From: Murphy, Alexander N [<mailto:alexander.murphy@mottmac.com>]
Sent: 15 November 2018 22:12
To: A303 Sparkford to Ilchester
Cc: Hayes, Elliot; Sanderson, Hannah; Paula McGeady; A303 Sparkford to Ilchester Dualling (A303SparkfordtoIlchesterDualling@highwaysengland.co.uk)
Subject: A303 Sparkford to Ilchester - S51 revised documents to PINS.

Please find below a response to the S51 advice together with an FTP site hosting the required files.

INSET F: EXISTING ROADS AND PROW TO BE STOPPED UP

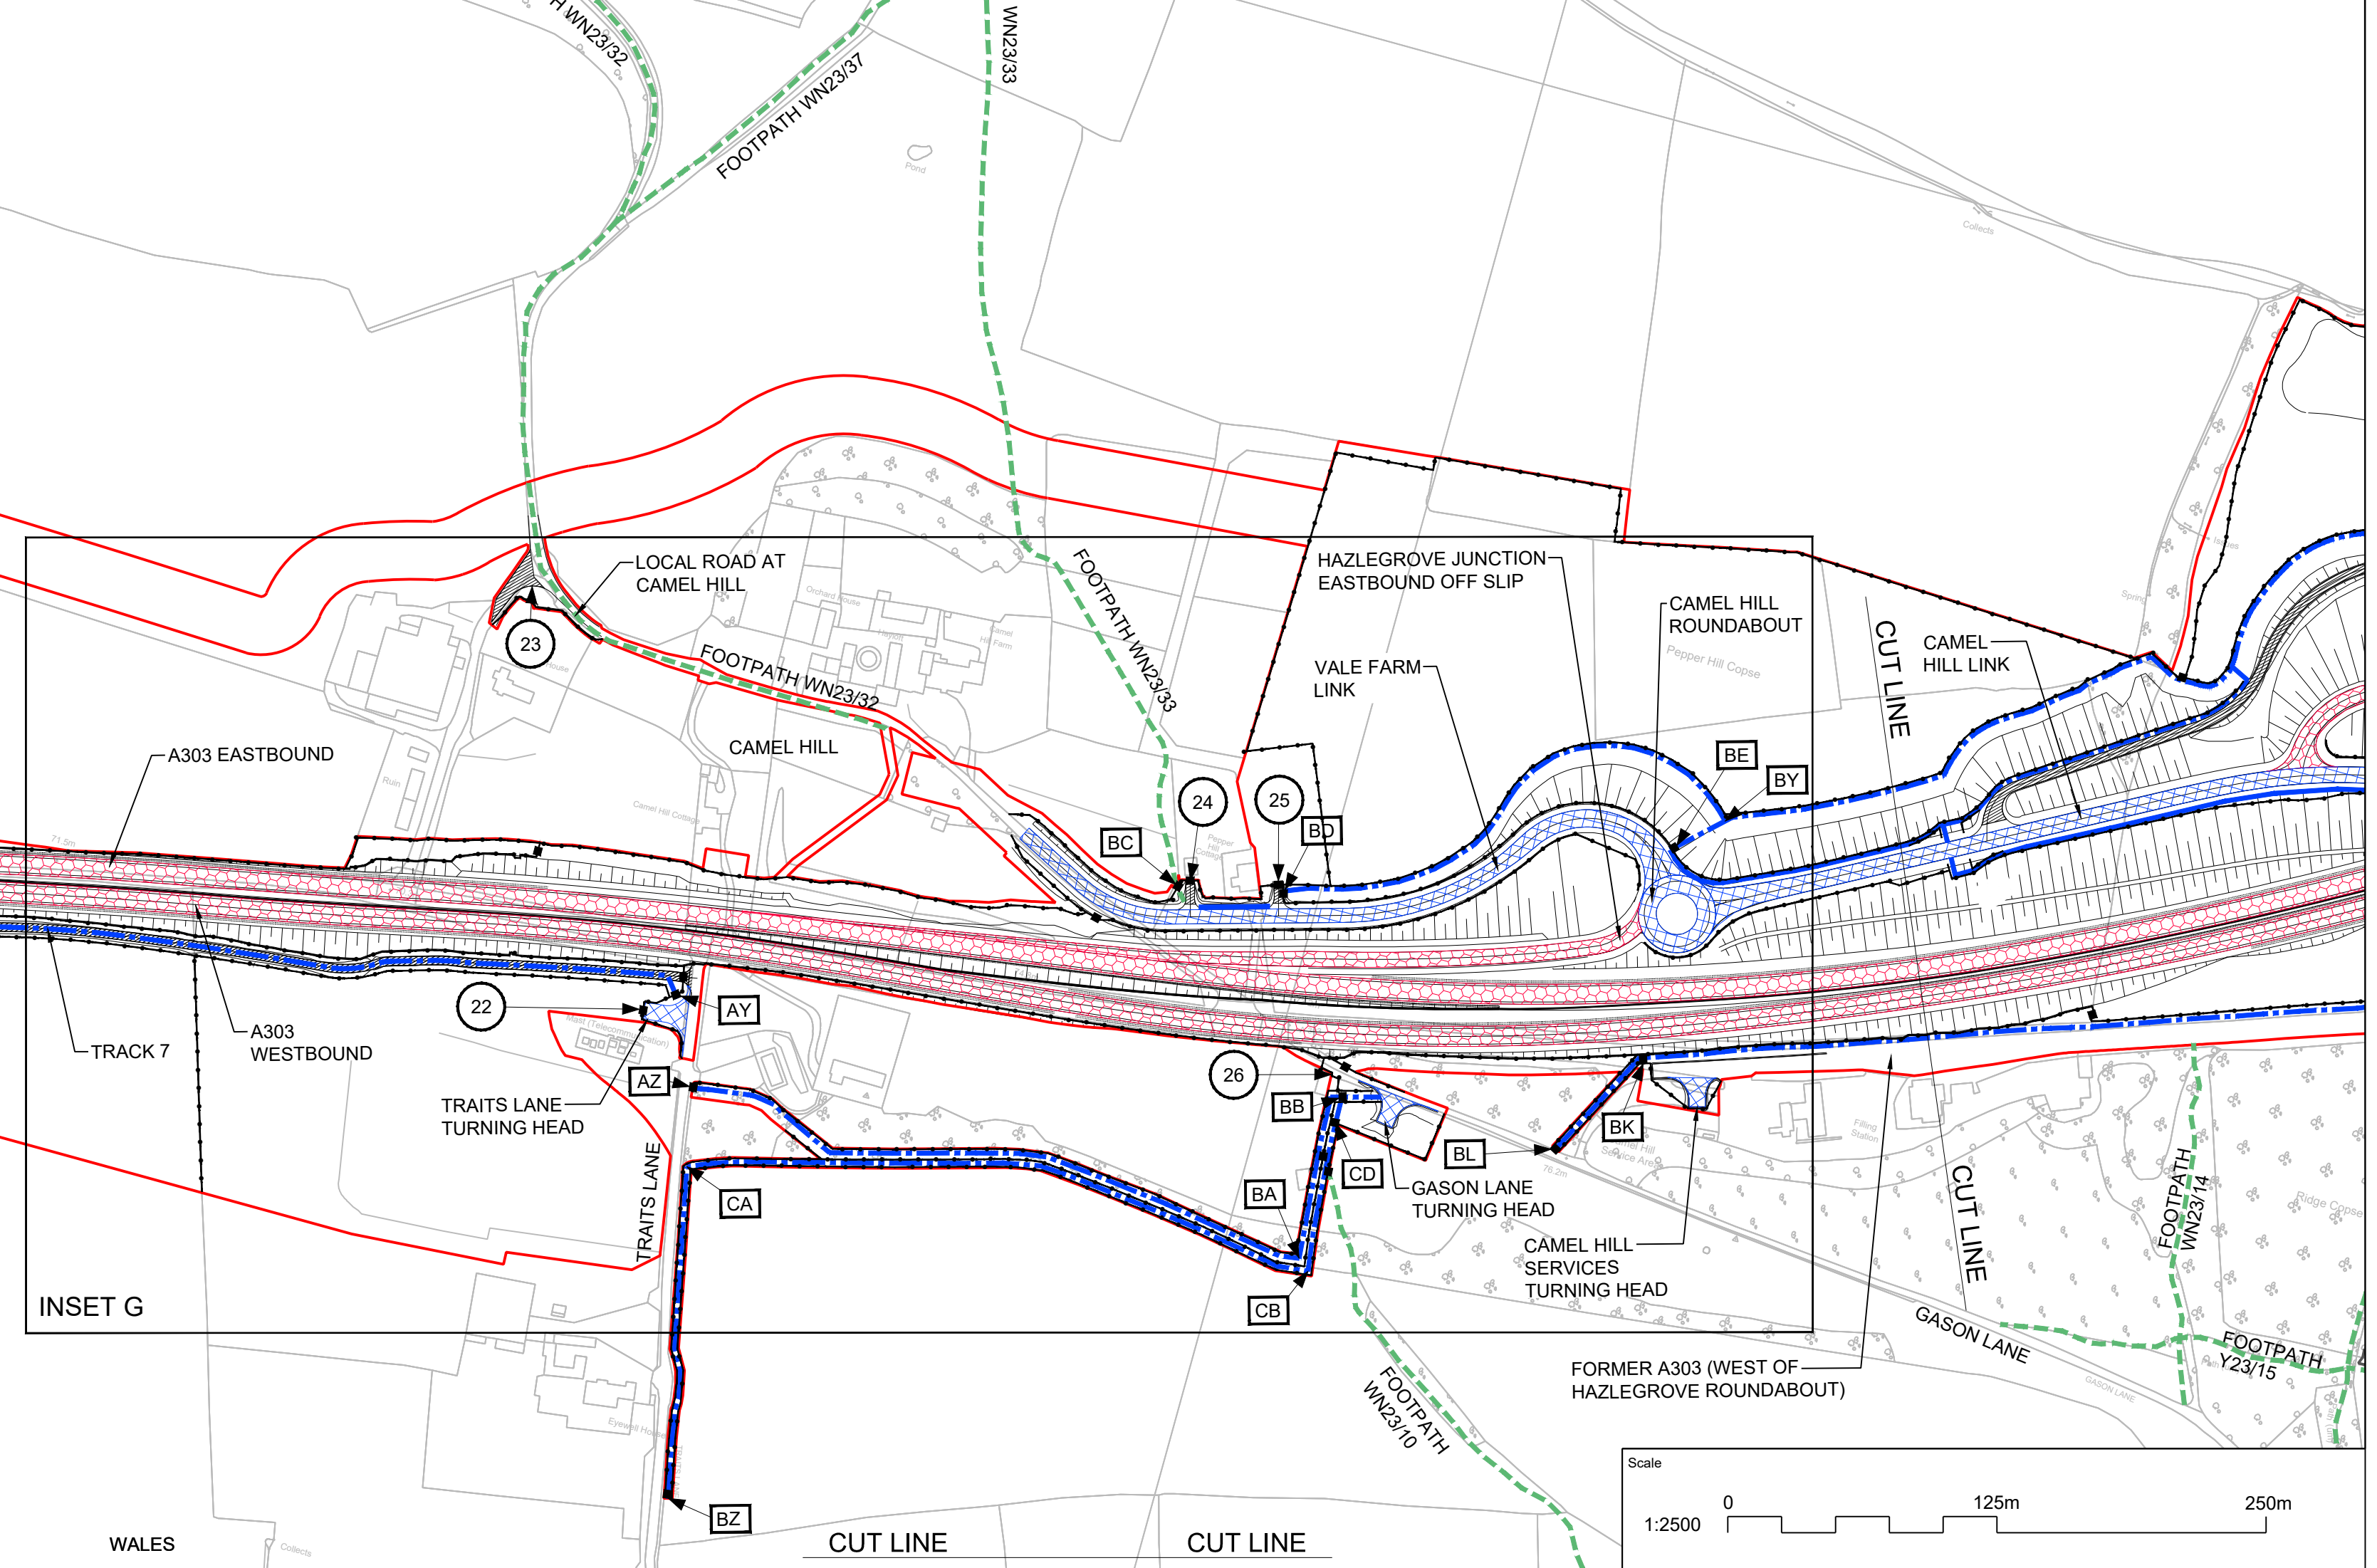
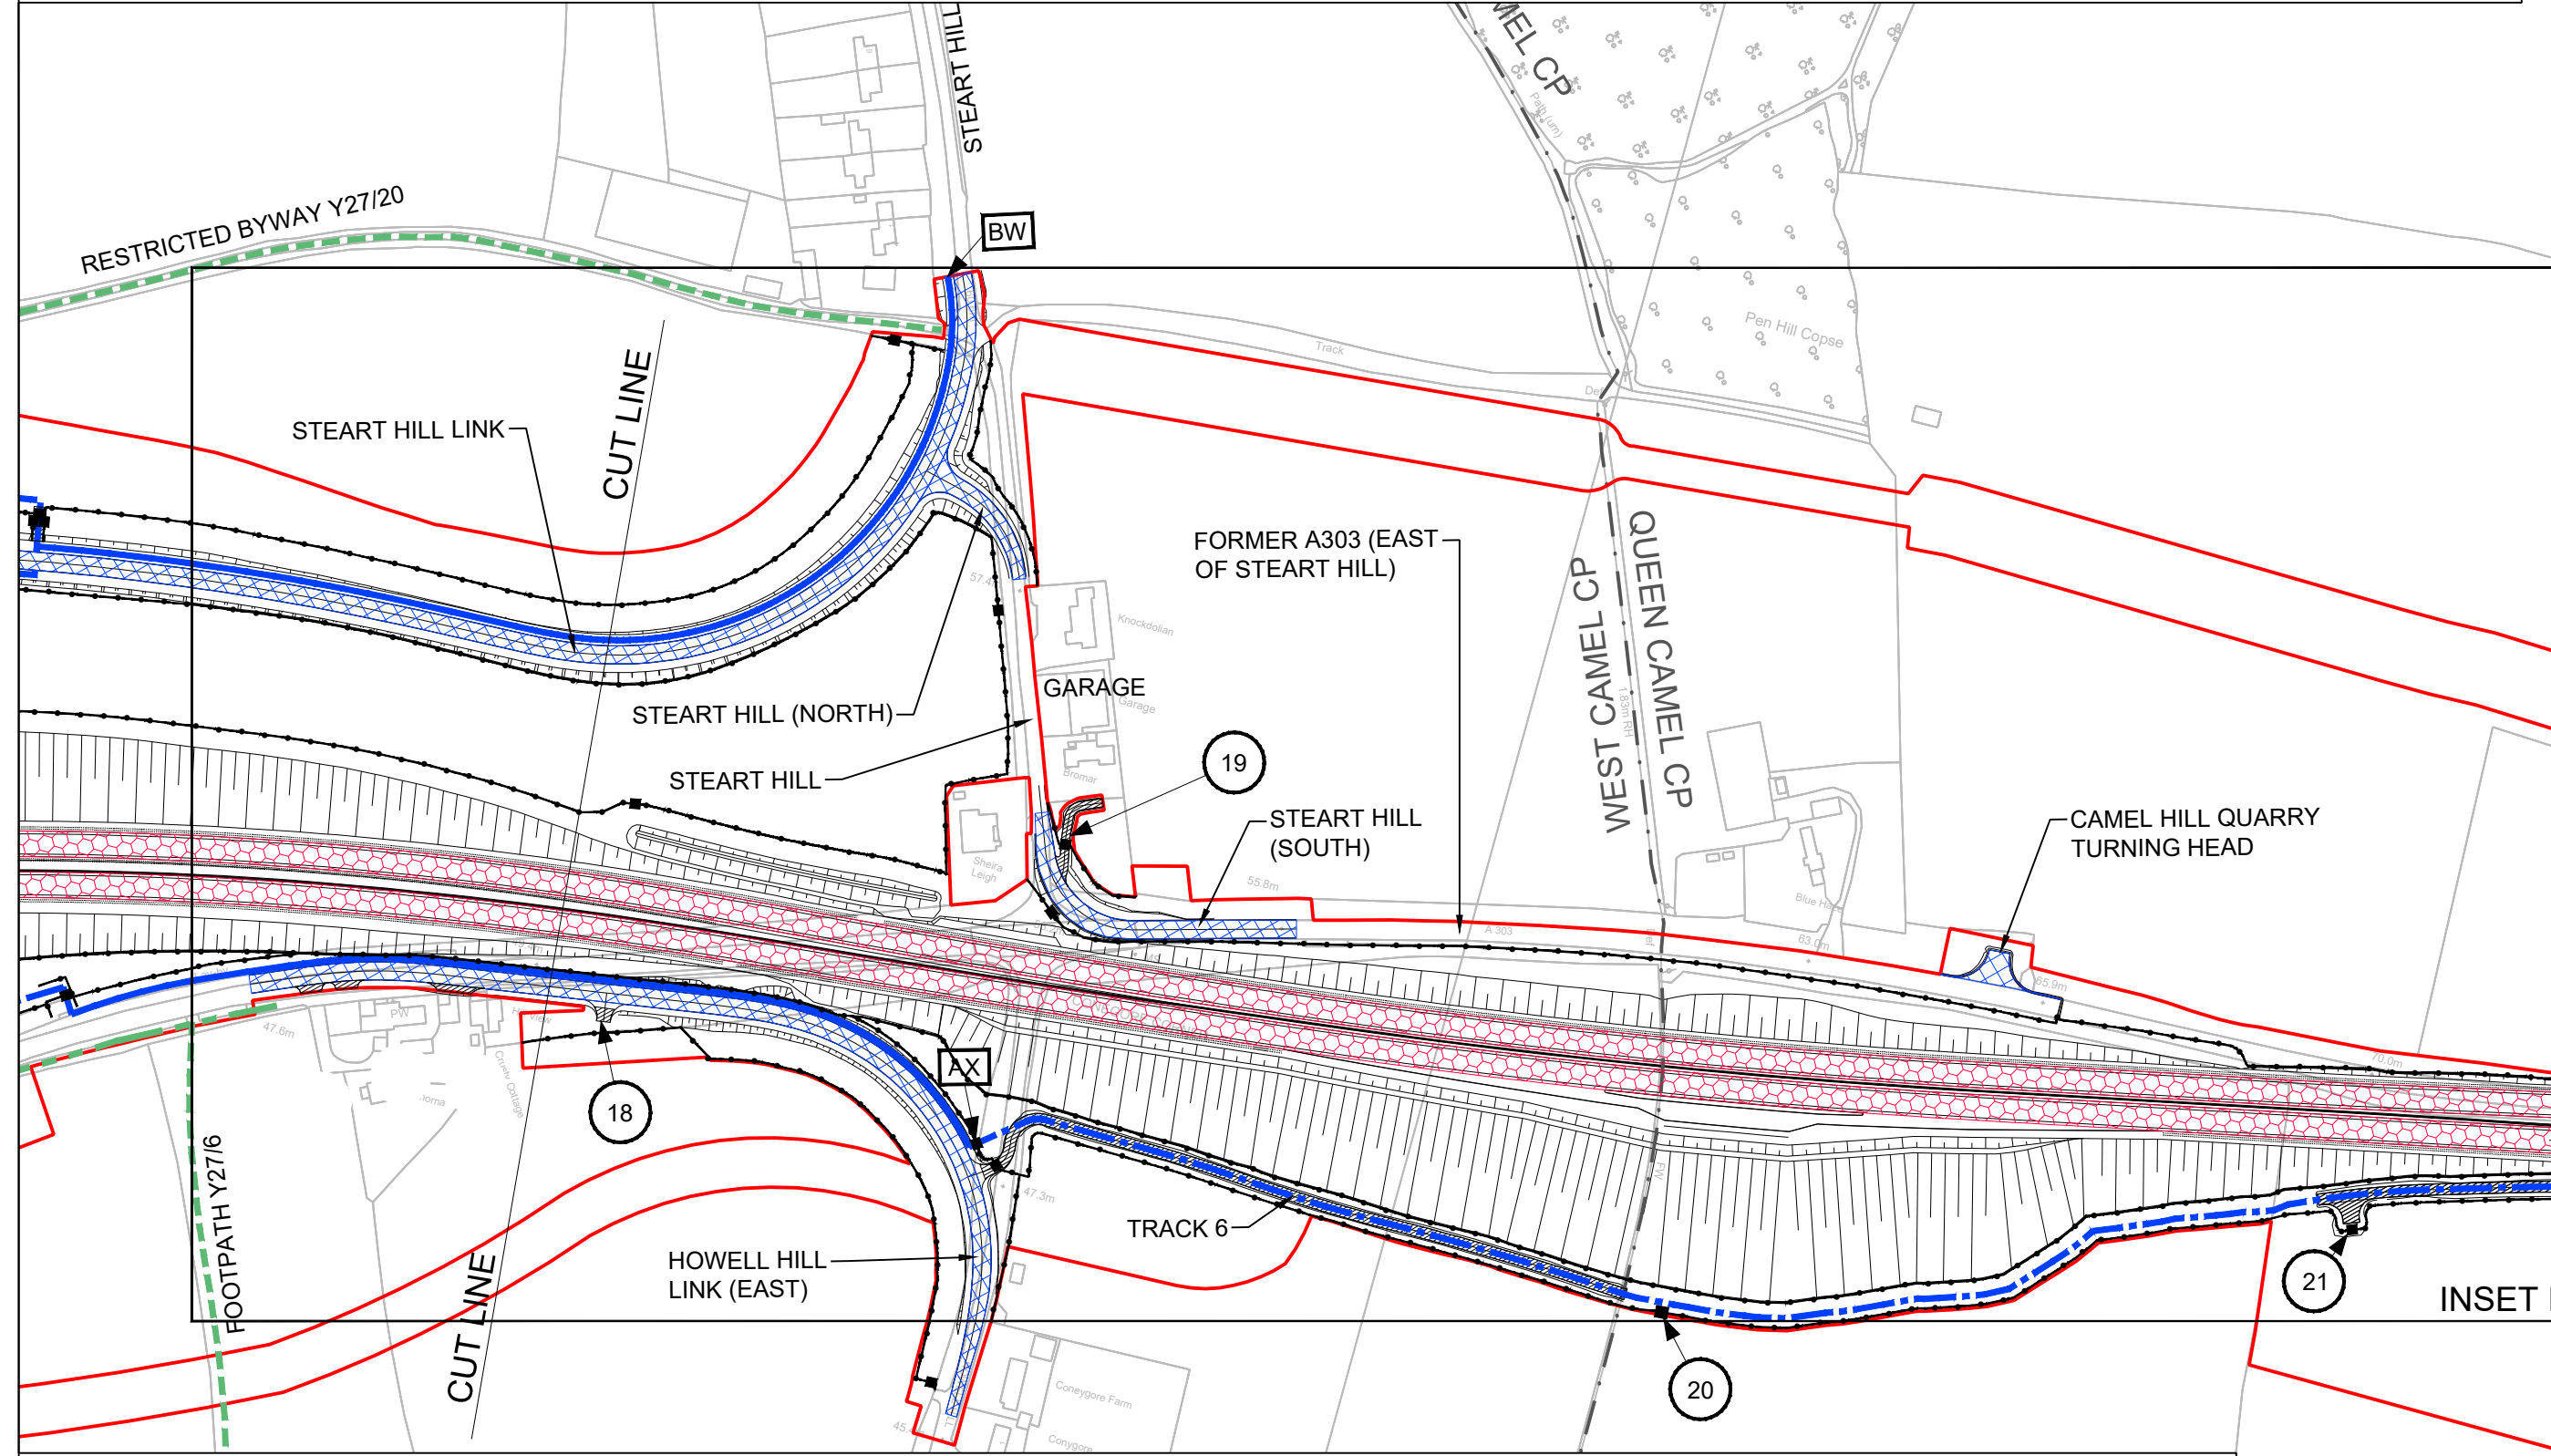
<p>-</p>	<p>Inset F of Sheet 3 of the Rights of Way and Access Plans (Document 2.4) was blank in the original version of the drawing. This was a drafting error. Sheet 3 has been corrected.</p>	<p>HE551507-MMSJV-LSI-000-DR-UU-2044 Rev C02</p>
<p>-</p>	<p>Surfacing and proposed hedgerows were not correctly shown at</p>	<p>HE551507-MMSJV-LSI-000-DR-UU-2066 Rev C02</p>

Drawing Title: **WORKS PLANS REGULATION 5(2)(j) SHEET 1 OF 4**

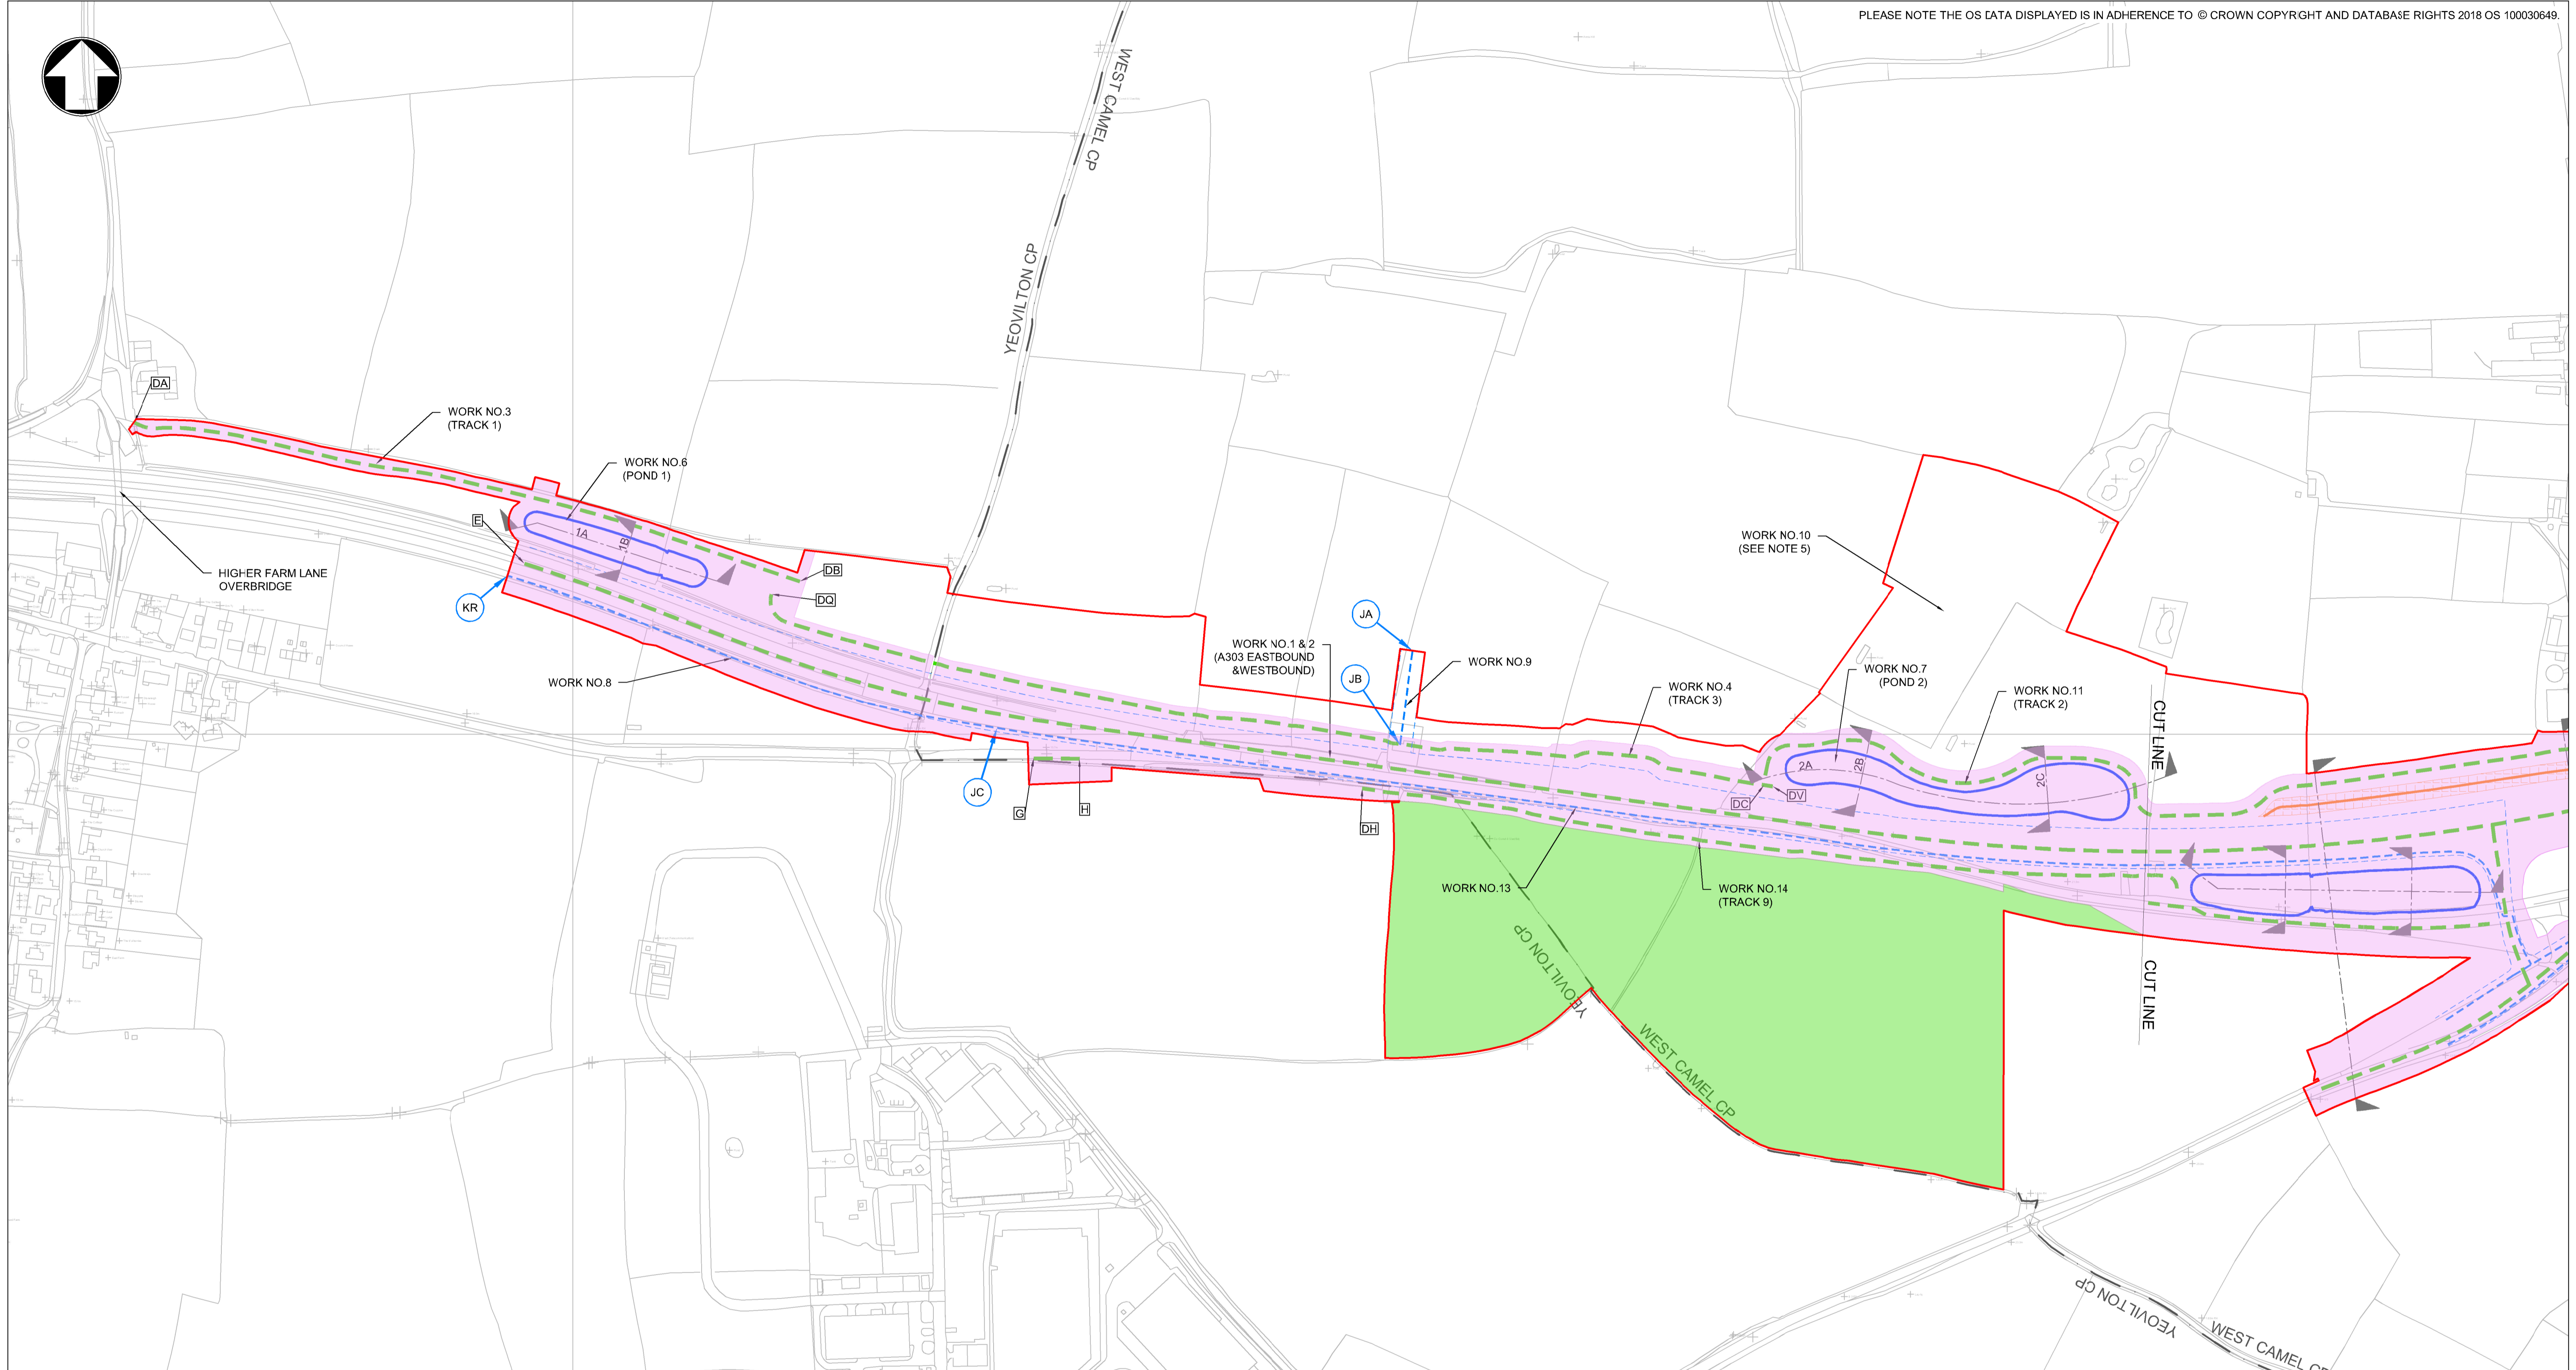
PINS Comment	Response	See updated plan
Work No.12 in Schedule 1 of the Draft Development Consent Order (Document 3.1) refers to point 'DE'. This point is not marked on the relevant Works Plan (Document 2.3)	Accepted. Point DE has been added to Sheet 1 of the Works Plans to reflect the reference in Schedule 1.	HE551507-MMSJV-LSI-000-DR-UU-2032 Rev C02
Work No. 61 in Schedule 1 of the Draft Development Consent Order (Document 3.1) refers to point 'EE' and this point is not marked on the relevant Work Plan.	Accepted. Point EE has been added to Sheet 3 of the Works Plans to reflect the reference in Schedule 1.	HE551507-MMSJV-LSI-000-DR-UU-2034 Rev C02
Work No.10 in Schedule 1 of the Draft Development Consent Order (Document 3.1) refers to an Ecological mitigation area. The limits of deviation for this work are not marked on the relevant	Accepted. Note 5 has been added to Sheet 1 of the Works Plans to clarify that the DCO boundary is the Limit of Deviation for	HE551507-MMSJV-LSI-000-DR-UU-2032 Rev C02 HE551507-MMSJV-LSI-000-DR-UU-2033 Rev C02
